1173 Riverside St.

Maine Indoor Sports

**CITY OF PORTLAND, MAINE  
DEVELOPMENT REVIEW APPLICATION  
PLANNING DEPARTMENT PROCESSING FORM**

Re: Maine Indoor Sports - 1173 Riverside Street

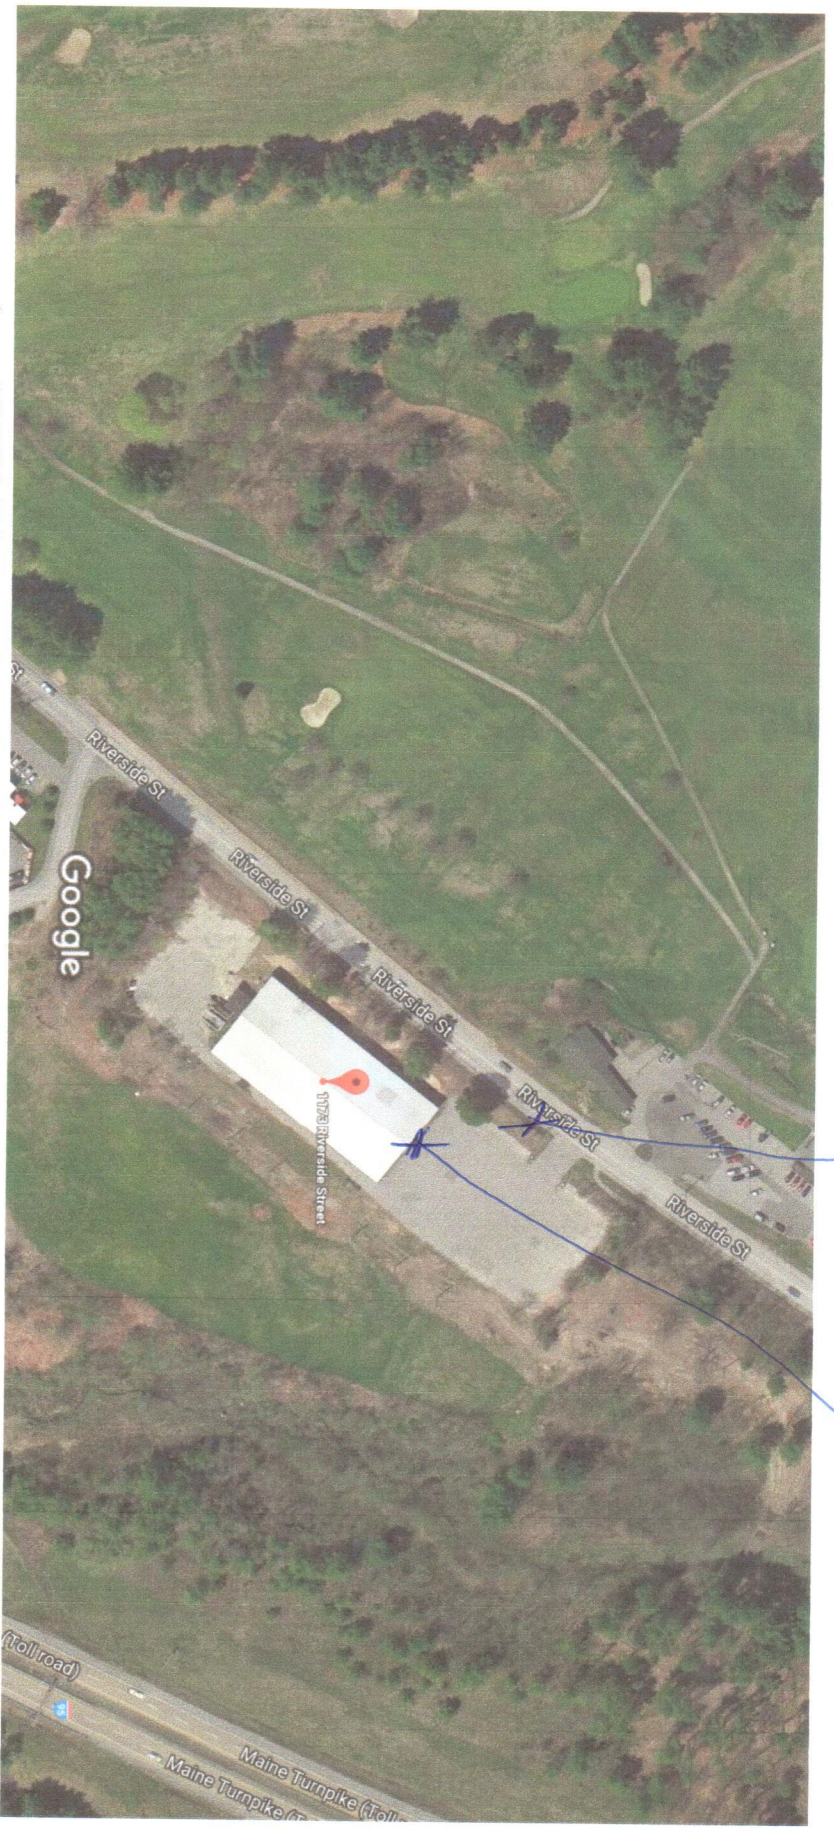
1. The existing parking lot appears to be in poor to average condition as it is cracked throughout and grass growth in the cracks is heavy. It is recommended that the pavement structure be evaluated by the applicant and that pavement repairs including crack sealing or full pavement overlay be performed.
2. The two existing catch basins must be cleaned and the frames and grates reset. Significant settlement has occurred around the basins as evidenced by a build up of sand and fine grained material around the structures, therefore the catch basins are not draining properly.
3. An existing cart path crosses the northwest corner of the property. The path goes to the City of Portland Driving Range. Either the path should be relocated or an easement provided to allow continued use.
4. The applicant should provide ability to serve letters from all serving utilities.

- Please formally submit this application to the Building Inspection Office.
- See memo from Steve Bushey dated 7-17-97.
- I know the primary use of the facility is an indoor recreation facility but I noticed in the submitted material reference to a "birthday party room." Are you going to be serving food? If so, how many seats and what floor area would be devoted to the dining area and cooking facilities. A reminder that a food service license would be required.

- Applicant should submit documentation on right title or on interest in the property such as a lease.
- Tom Errico indicates that Jack Murphy's suggestion of two 11 foot exit lanes and a 16 foot entrance lane is o.k. for the driveway entrance.

- Where will solid waste be stored? If its an outside dumpster, it should be screened with a solid wood fence and gate.
- Please clarify on the plan what vegetation is going to be preserved.
